Horsley Drive Business Park Stage 2 – MOD 1 (SSD 7664)

Thank you for your email dated 1 April 2020 inviting WaterNSW to comment on the modification report for the Horsley Drive Business Park Stage 2 – Modification 1.

WaterNSW has reviewed the modification report and provides the following comments:

Figure 3 SSD10404 proposed works and the Upper Canal

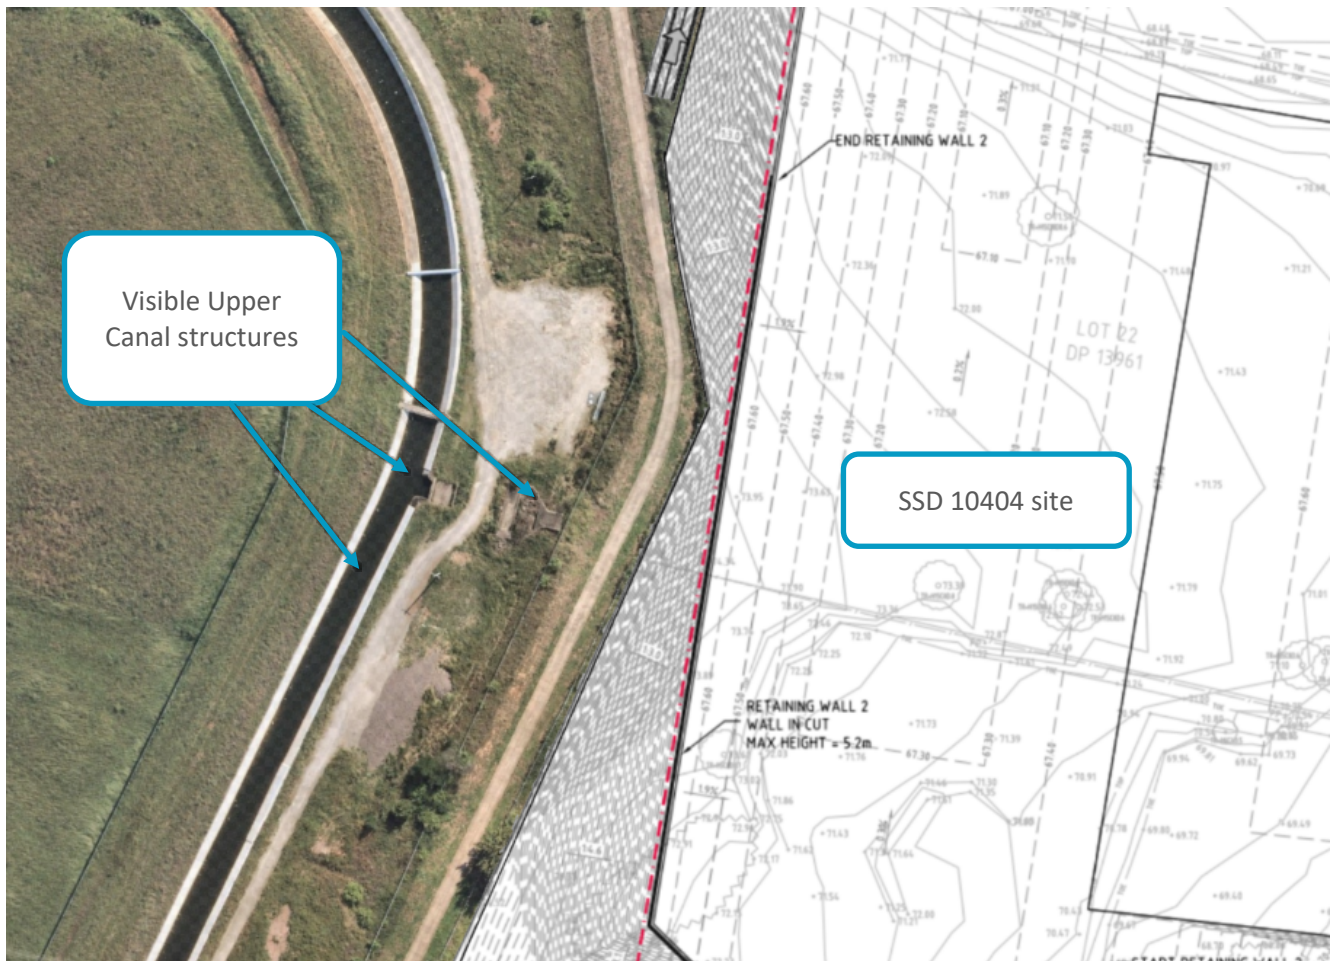
The Construction Noise and Vibration Management Plan (SLR, January 2020) does not list the WaterNSW Upper Canal as a sensitive receiver, considering its age and proximity to the site. However, Figure 4 indicates that controls are required for vibration intensive equipment working near the Upper Canal structure.

- *Prior to commencement the proponent is to confirm with and advise WaterNSW of the potential vibration impacts on WaterNSW's Upper Canal structure.*
- *Vibration mitigation measures are to be implemented as per the Construction Noise and Vibration Management Plan.*
- *The proponent is to consult with WaterNSW on the vibration monitoring mitigation measure prior to its application.*
